Application No: EP/128/20/HH
Site Address: 48 Angmering Lane East Preston BN16 2TA
Description of works: Erection of a two storey rear extension. Existing brick house to be rendered in white with alterations to fenestration

Thank you for your internet representation made on 18th November 2020 which has been recorded as an objection with the comments as follows:

Drawing No. 0009 Drawing Name: Proposed Roof Plan

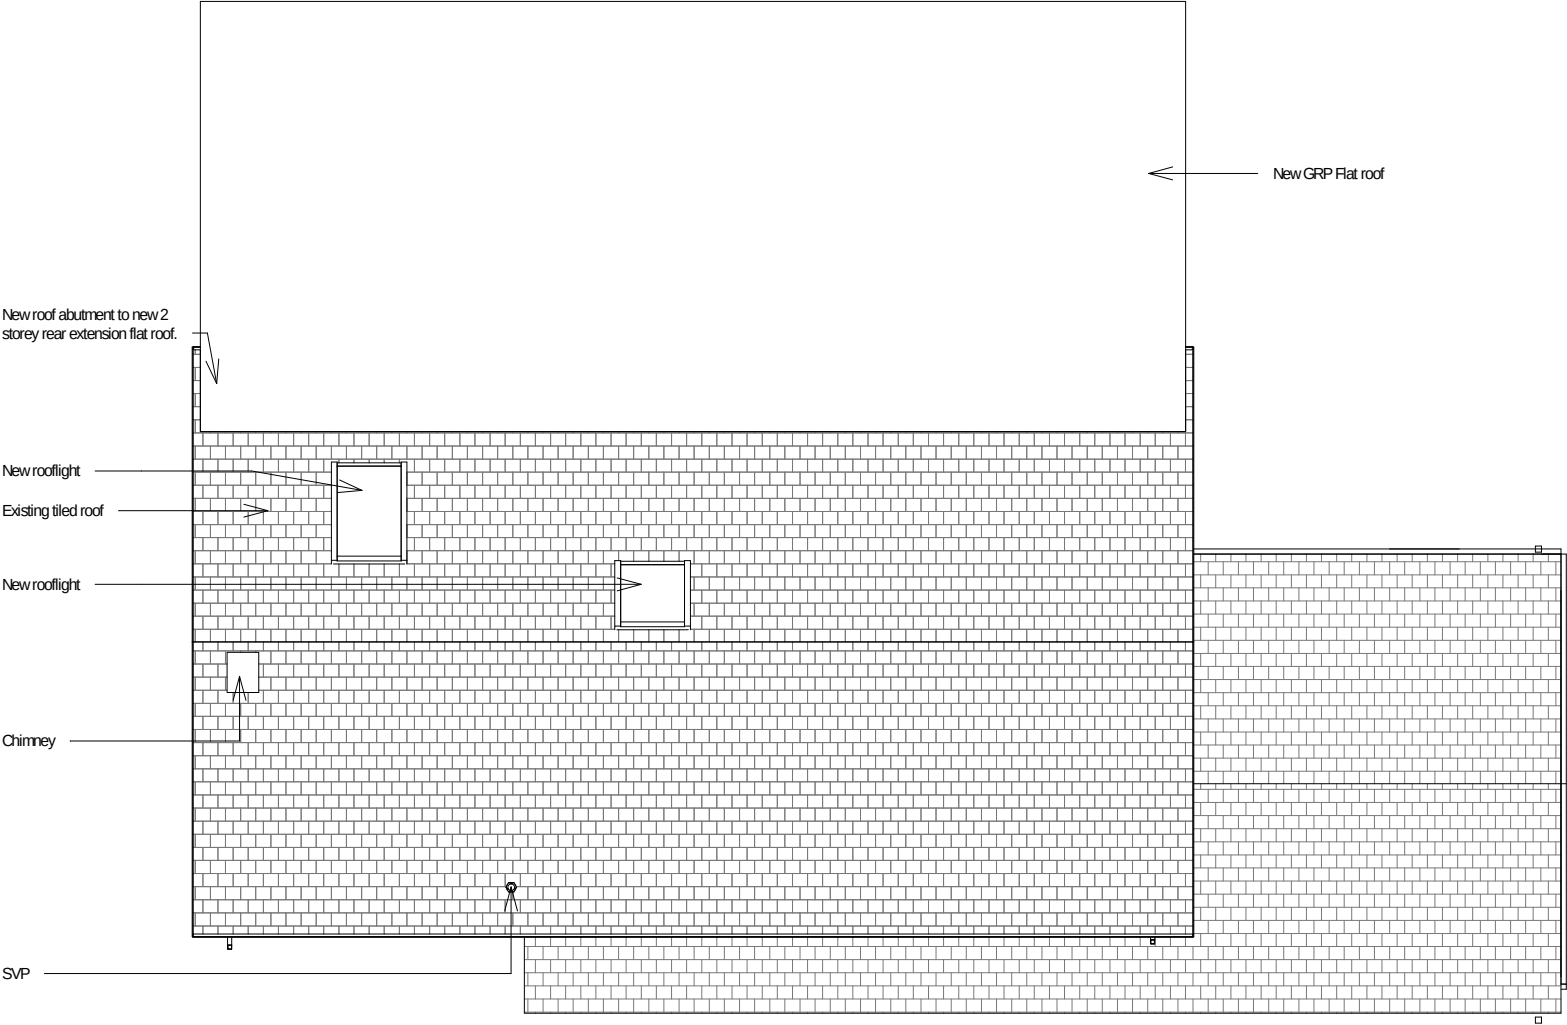
The proposed extension seems conspicuous and out of keeping. The flat roof compromises the integrity of the original house.

Drawing No. 0010 Drawing Name: Proposed Elevations

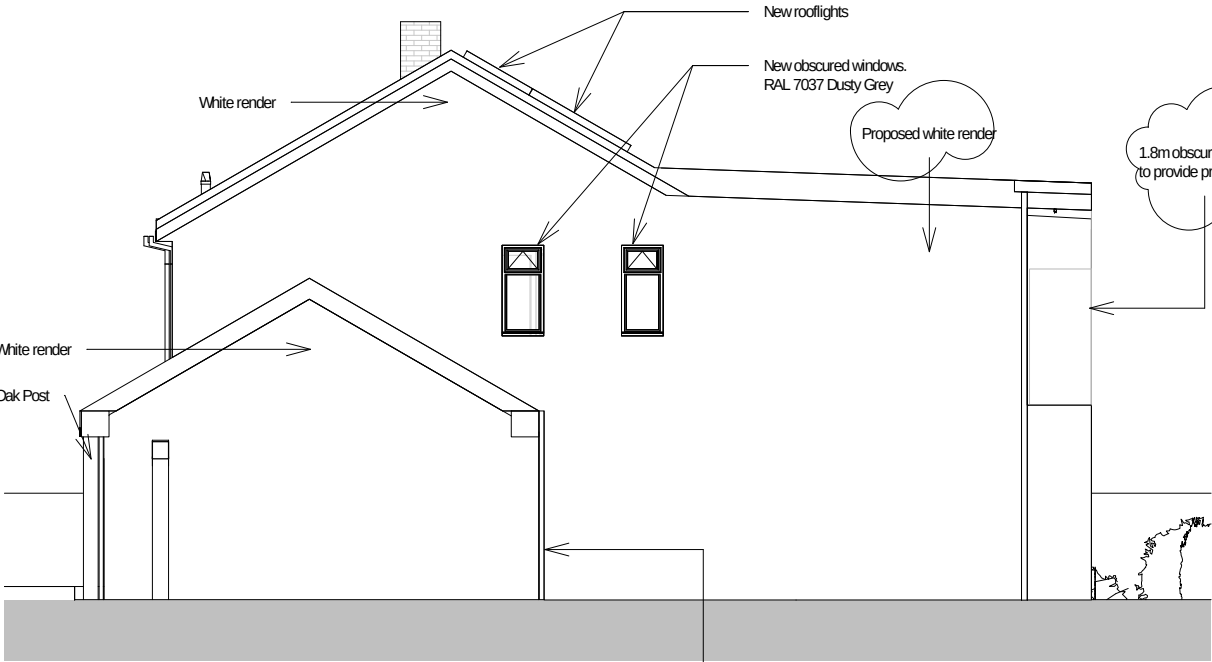
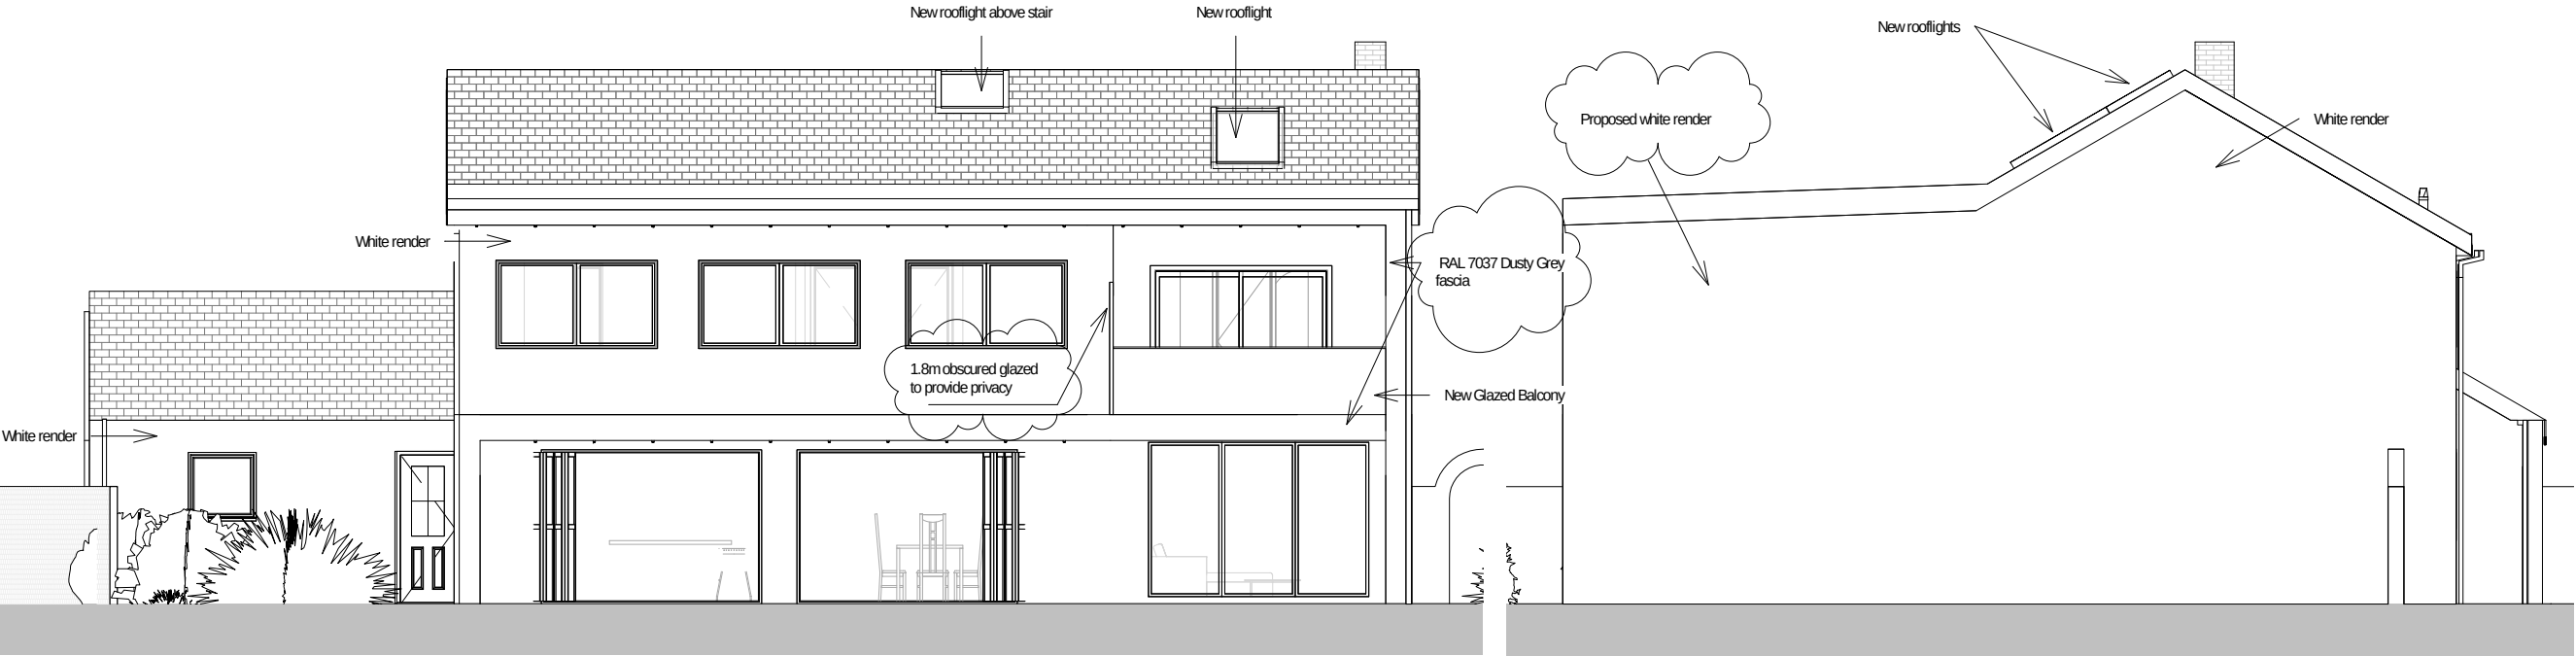
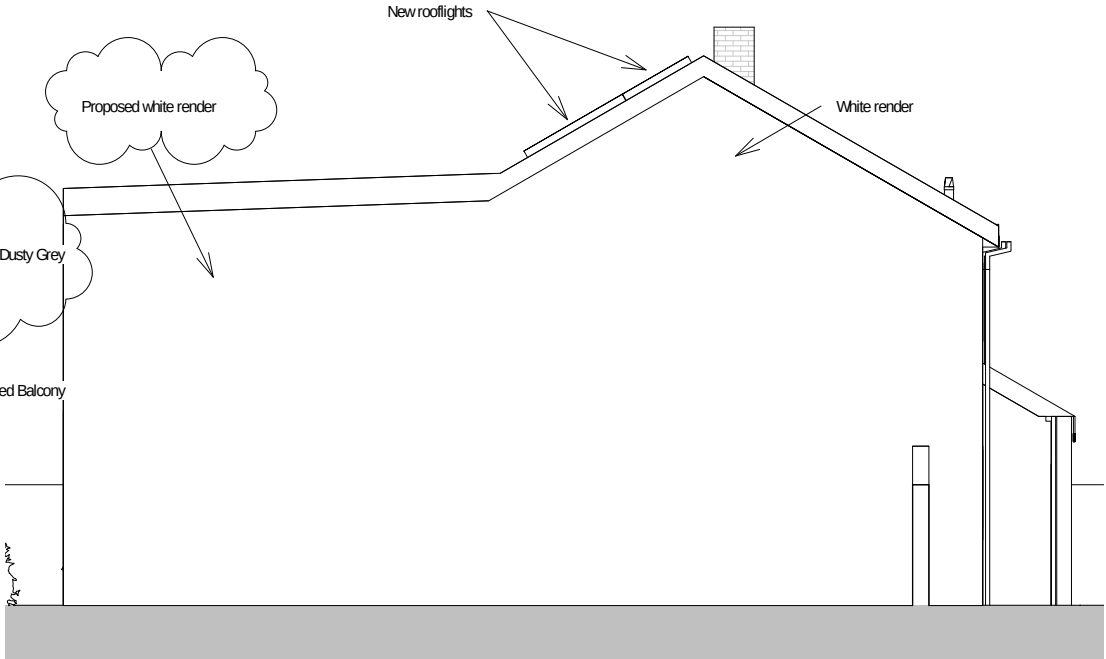
The proposed north and south elevations would alter the street scene adversely when travelling up or down Angmering Lane.
